Our Ref: EN010128

Date: 29/11/2024

### **Application by Cory Environmental Holdings Limited for an Order Granting Development Consent for the Cory Decarbonisation Project**

#### **Notice by Applicant of Intention to Submit a Request for Proposed Changes to the Development Consent Order (DCO) Application**

DRAWING TITLE:
**CARBON CAPTURE FACILITY
INDICATIVE ELEVATIONS
REGULATION 5(2)(o)
APPLICATION DOCUMENT
REFERENCE 2.10**

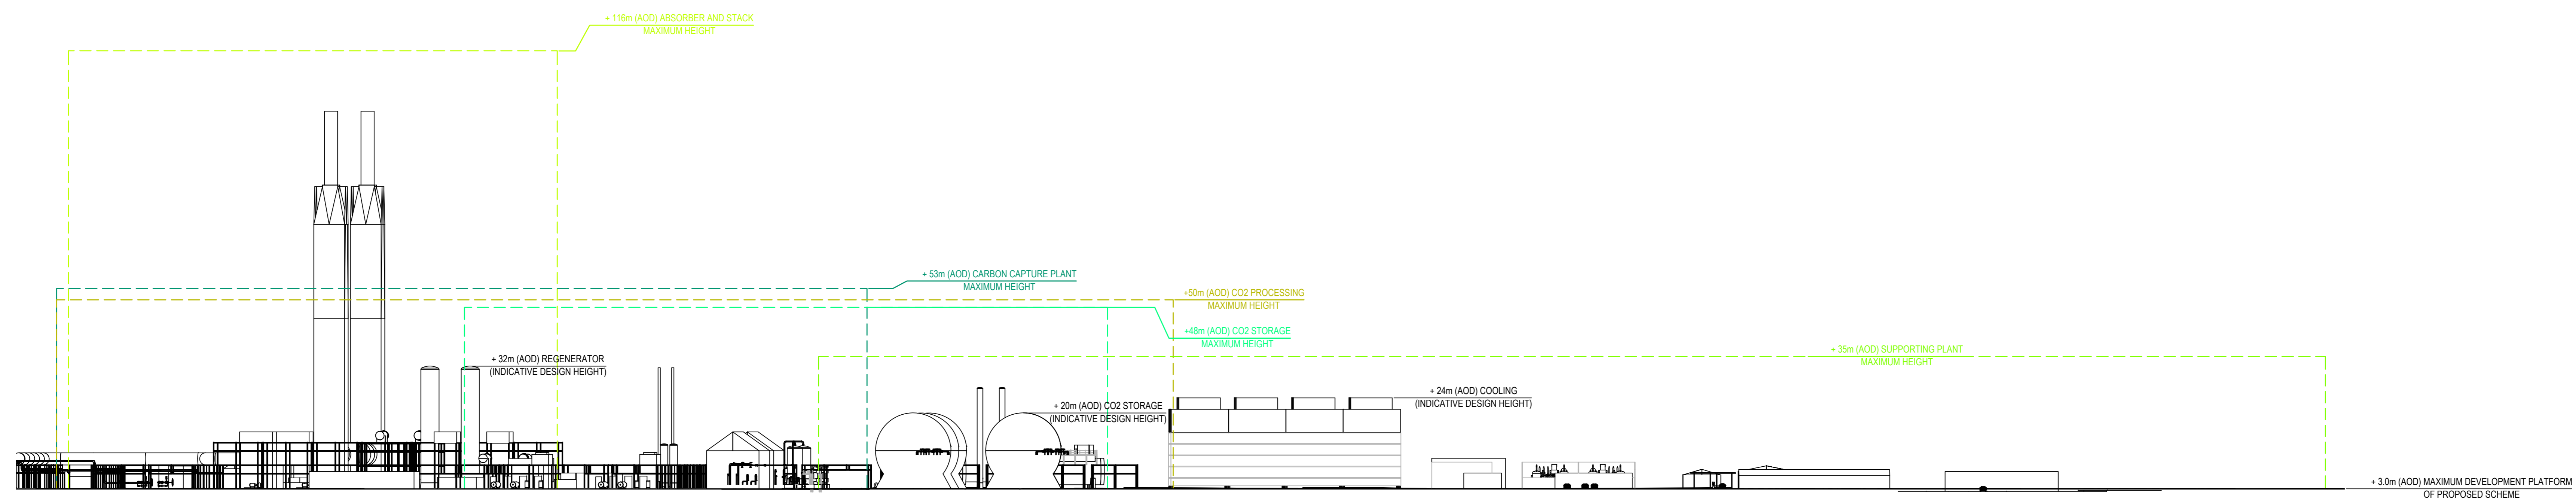
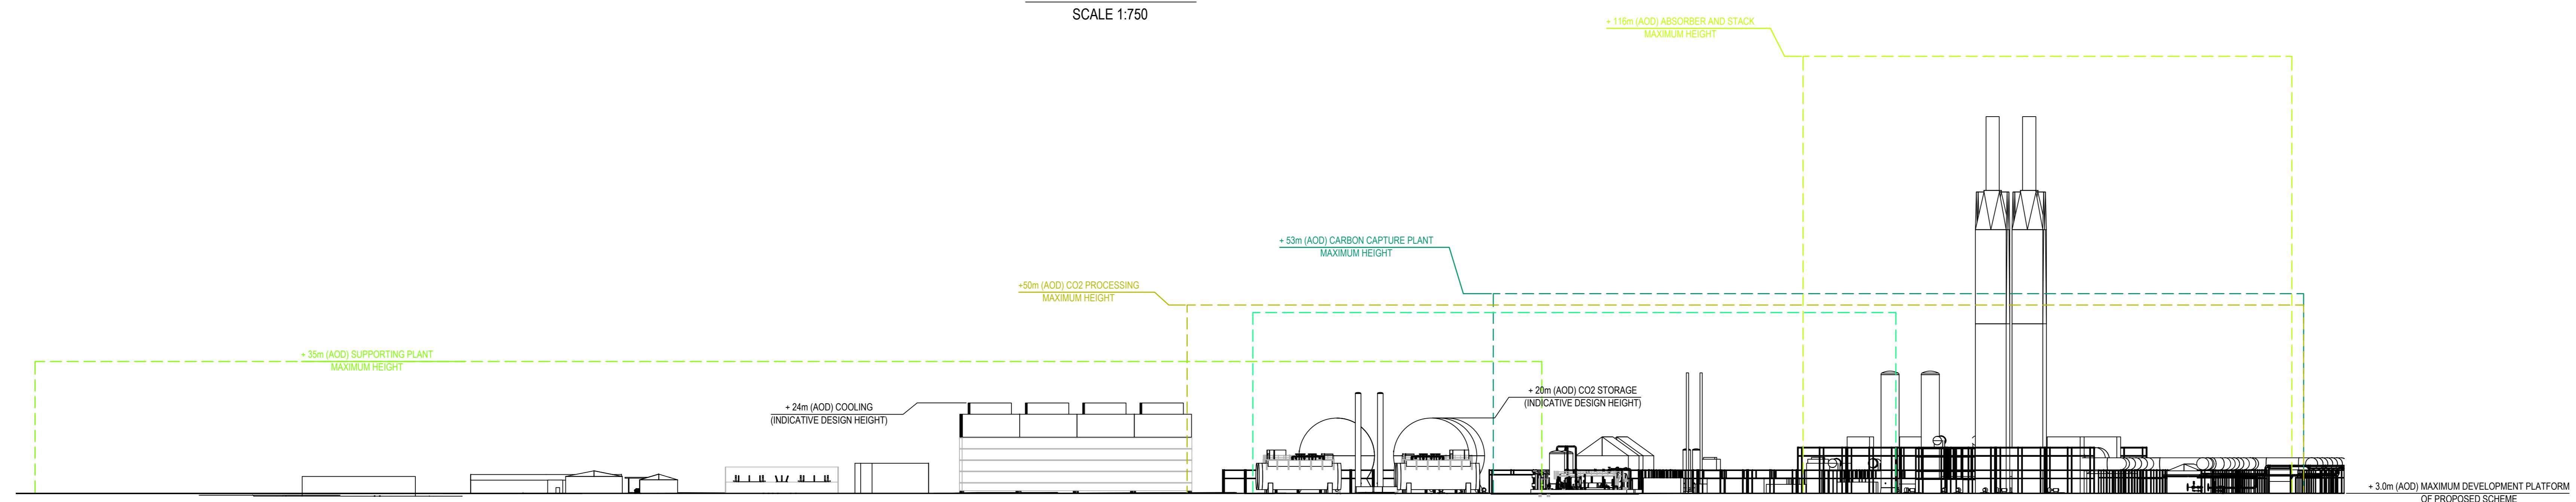
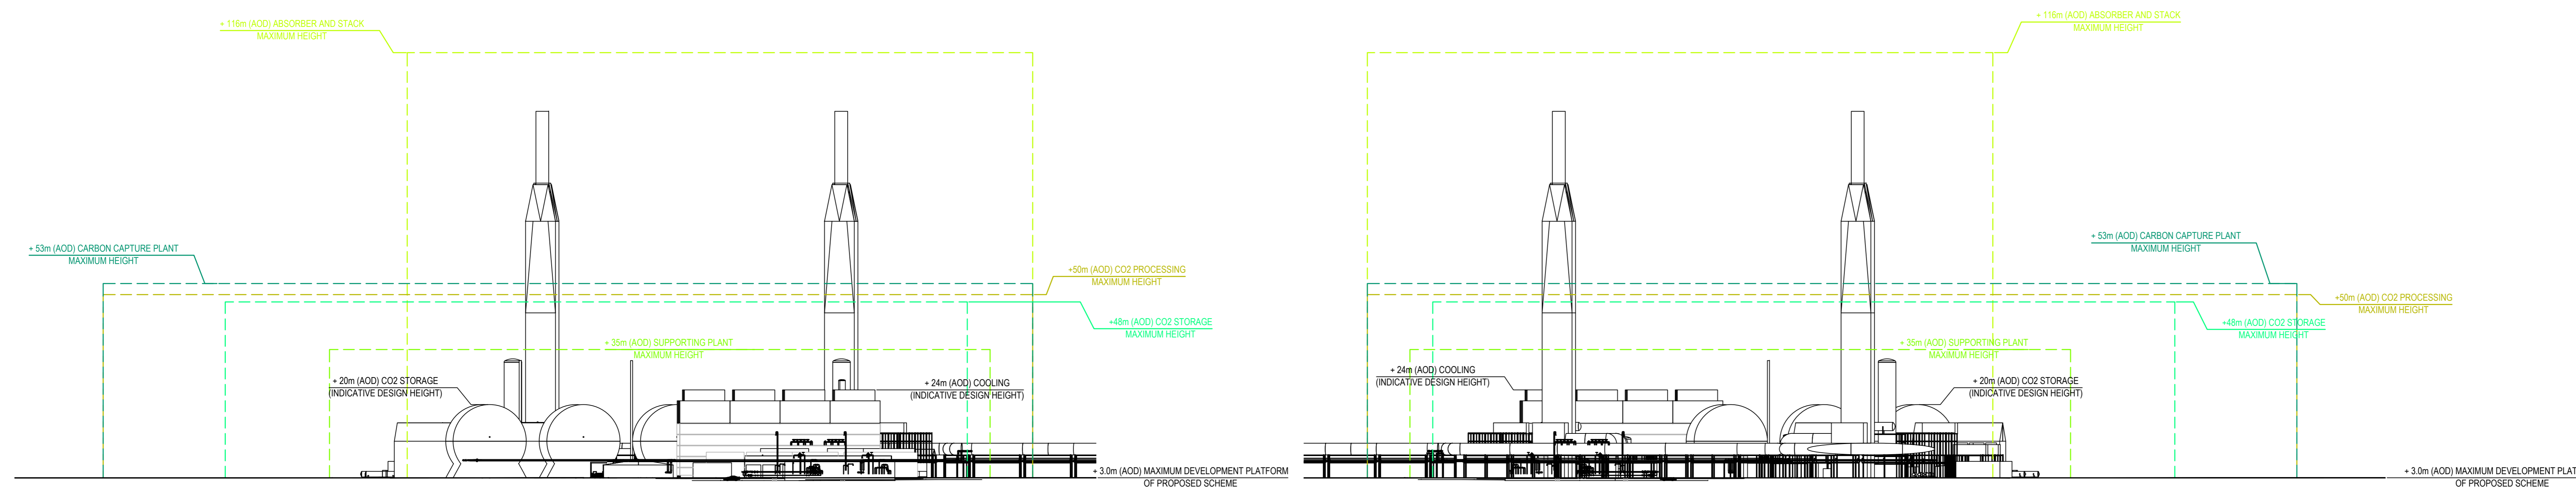
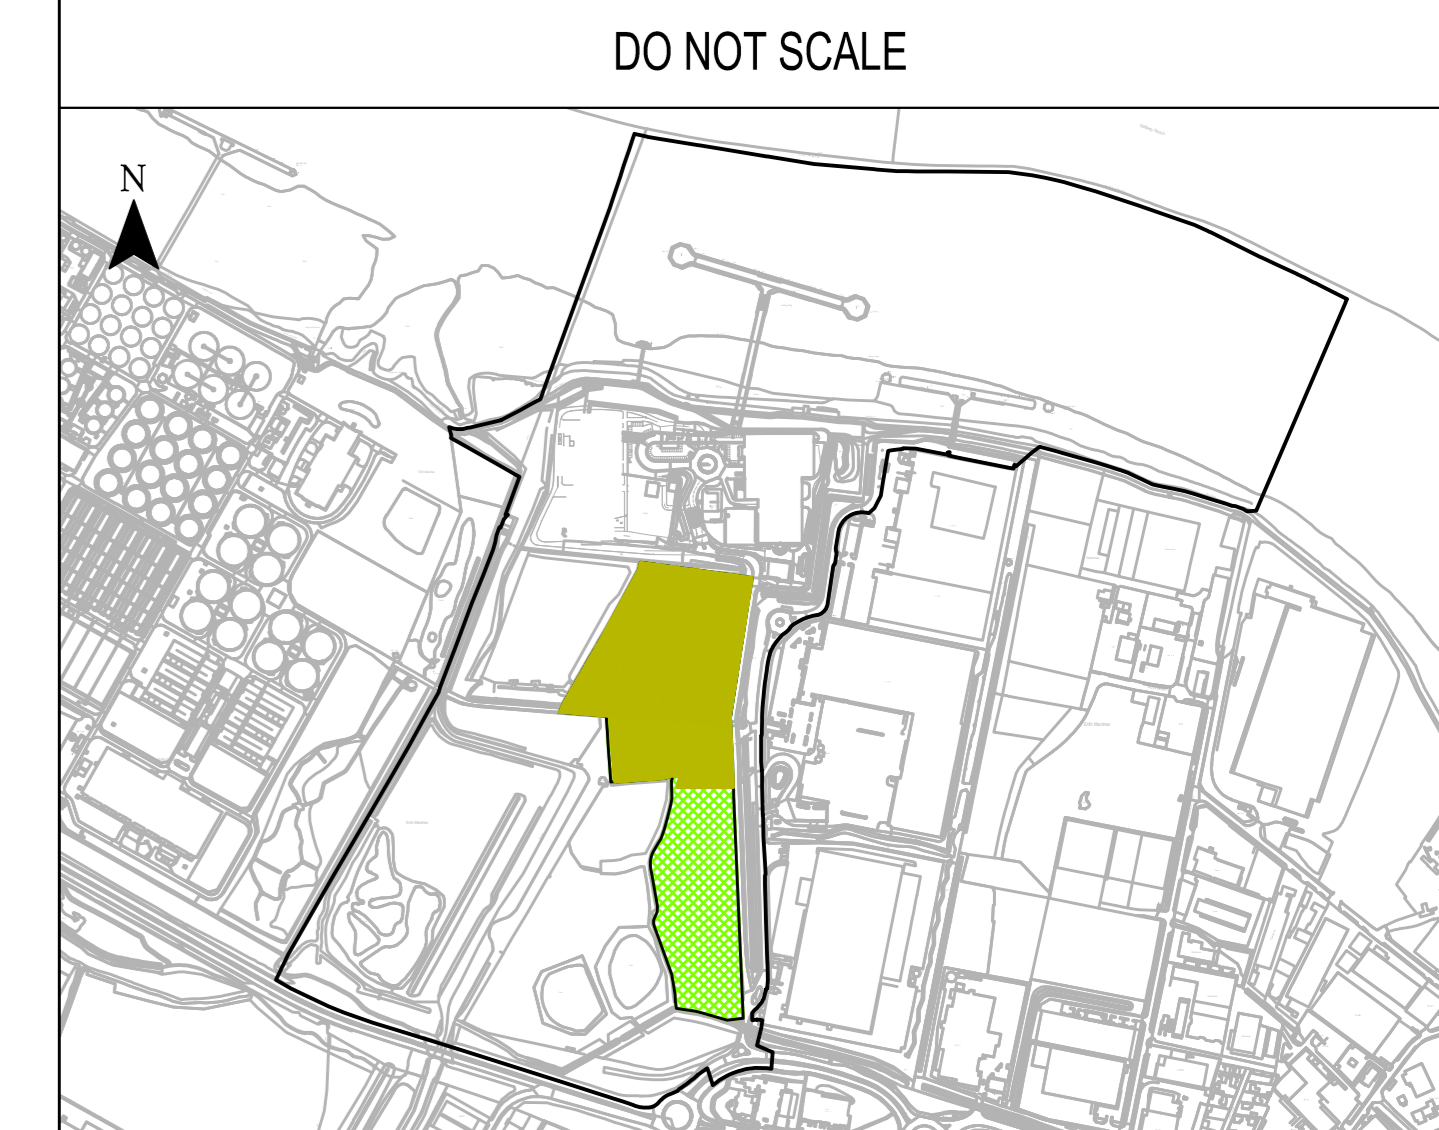
Given that the Indicative Elevations [APP-016] show combined Absorber Columns and Stacks and are annotated to the effect that the indicative design height of the Regenerators would be 32m (AOD), it will be important to illustrate the proposed changes in a similar manner, acknowledging that they are indicative. Similarly, it is noted that Applicant intends to provide revised Photomontages [APP-104]. The applicant should
